From: Wolfenbarger, Jeanne
Sent: Friday, June 19, 2015 4:08 PM
To: 'David Soule'
Subject: F22-D002 (Sandia Area Federal Credit Union/Starbucks)

I have reviewed the latest drainage submittal and still need to have the following comments addressed prior to approval:

DRAINAGE AND TRANSPORTATION INFORMATION SHEET

Project Title: sandia area federal credit union-starbucks Building Permit #: _____ City Drainage #: f22-f002
DRB#: _____ EPC#: _____ Work Order#: _____
Legal Description: lots 3a,3b,3c new holiday park
City Address: 13101 montgomery ne

OVERFLOW CROSS SECTION

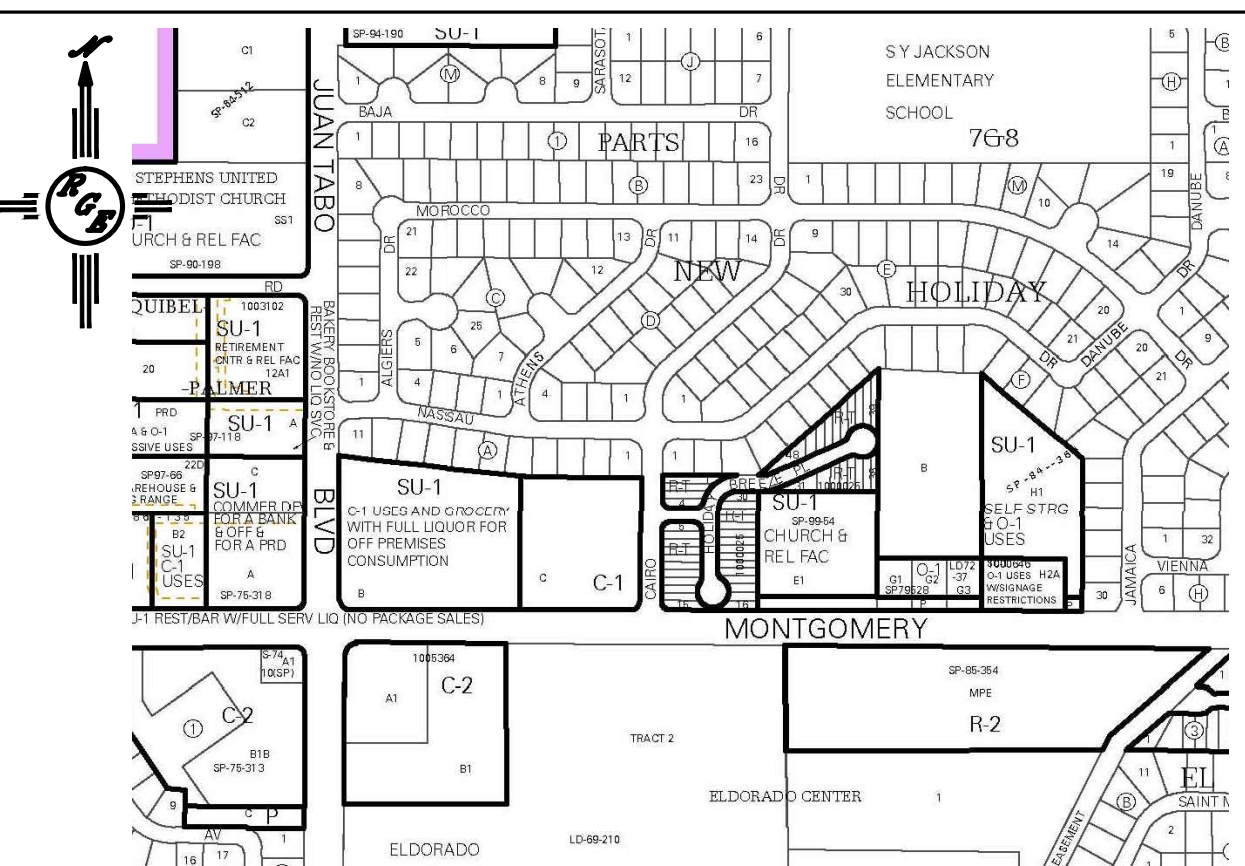
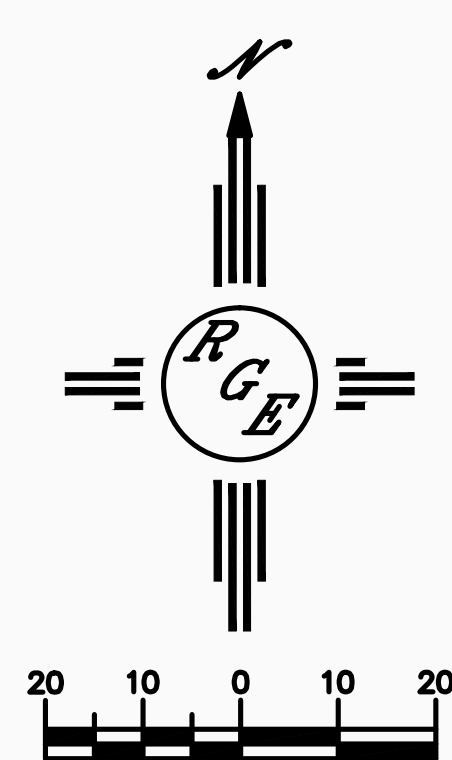
3. Label all pipe sizes on the plan. There are some short pipe runs especially from the that are missing pipe size call-outs.
4. Provide detail for the 10-foot by 6" emergency overflow from the temporary pond. List the elevations. (It would make sense that the above invert elevation within the pond is above the WSEL Elevation from the upstream pond when labeling it.)

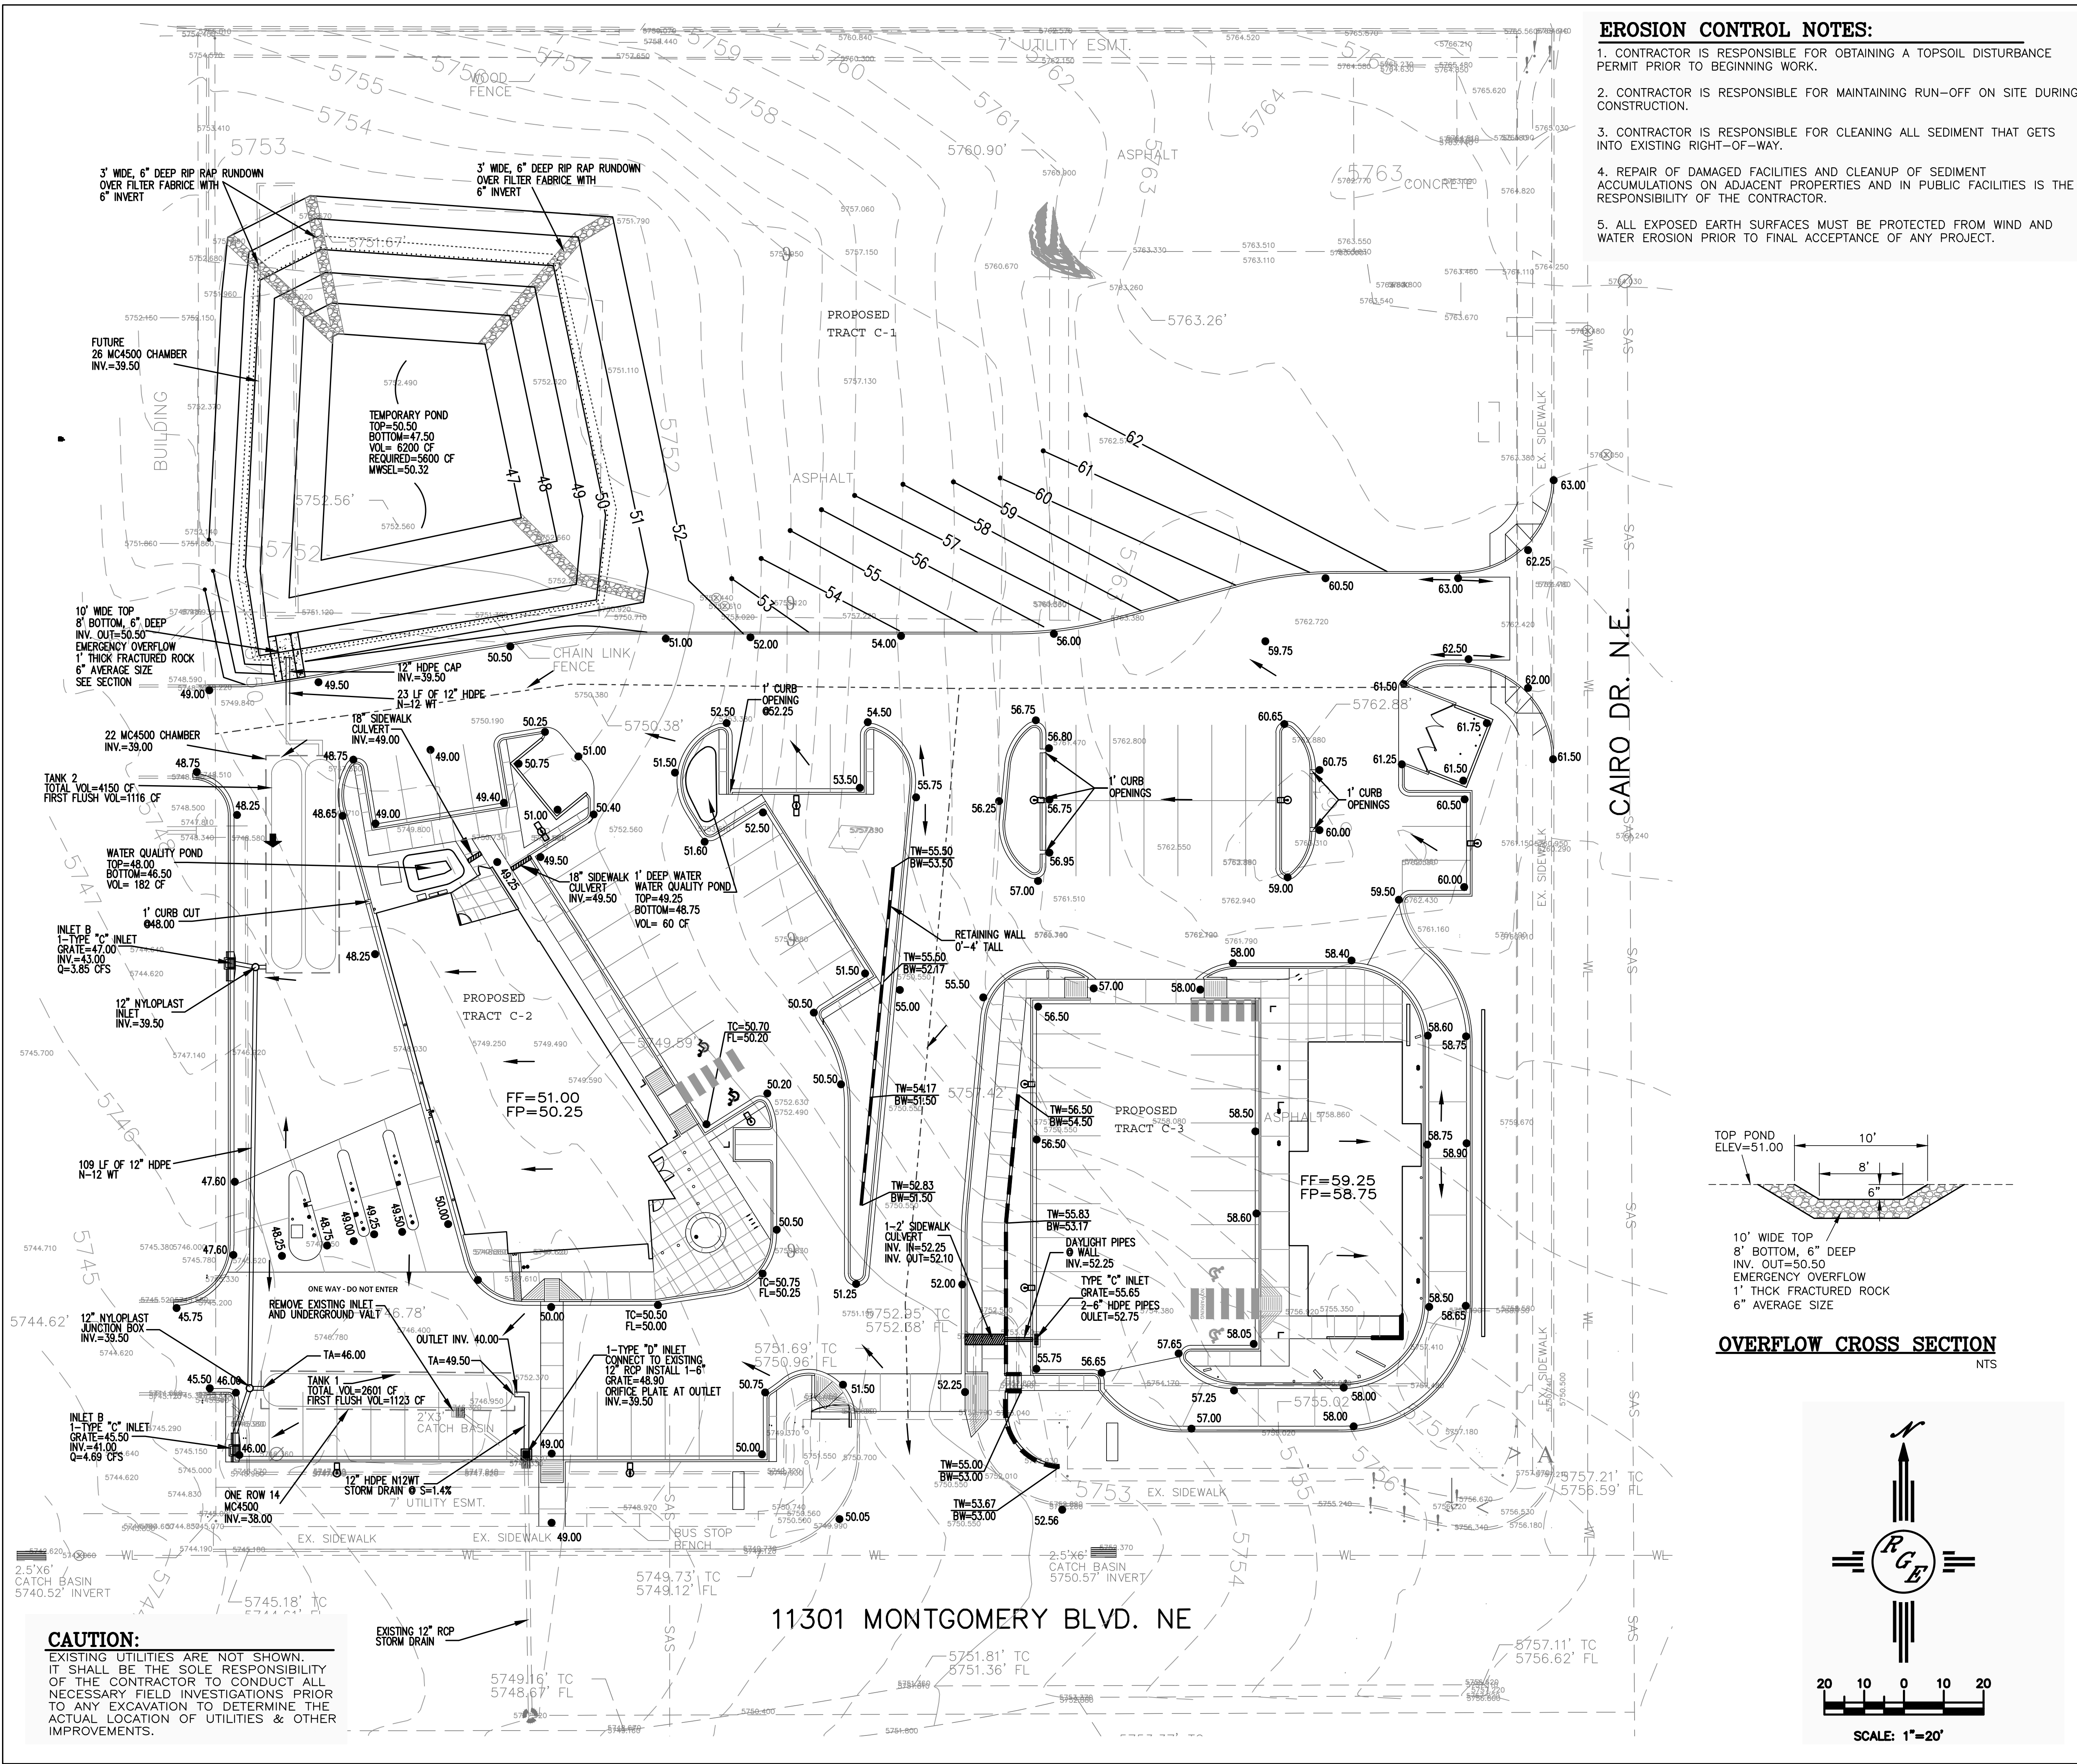
1. If the temporary pond is now sized to handle the 100-year 10-day storm runoff, label the WSEL Elevation within the pond on the plan view.
2. On the actual grading and drainage plan view, label the first flush volume for each run of the storm chambers that corresponds with drainage write-up. Also, label the total volume provided by the storm chambers on the plan view that corresponds with the drainage write-up. (Provide this information directly under the label showing number of storm chambers for each run of the storm chambers.)

5. On the water quality pond in the middle of the site, the top elevation of 49.25 is far lower than the adjacent curb cut elevation opening of 52.25 and other adjacent curb elevations. Revise as necessary.

6. On the water quality pond on the west side of the site, there are top of pond elevations of 46.5 shown where the adjacent sidewalk would be approximately 4 feet higher based on the adjacent curb flowline elevations, and the adjacent building is also approximately 4 feet higher. Revise as necessary.

7. There are new 18-inch sidewalk culverts called out on the plan near the water quality pond to the west that have no elevation information listed. Also, how does water drain from the other 18-inch sidewalk culvert to this one? Provide a couple more spot elevations for information.
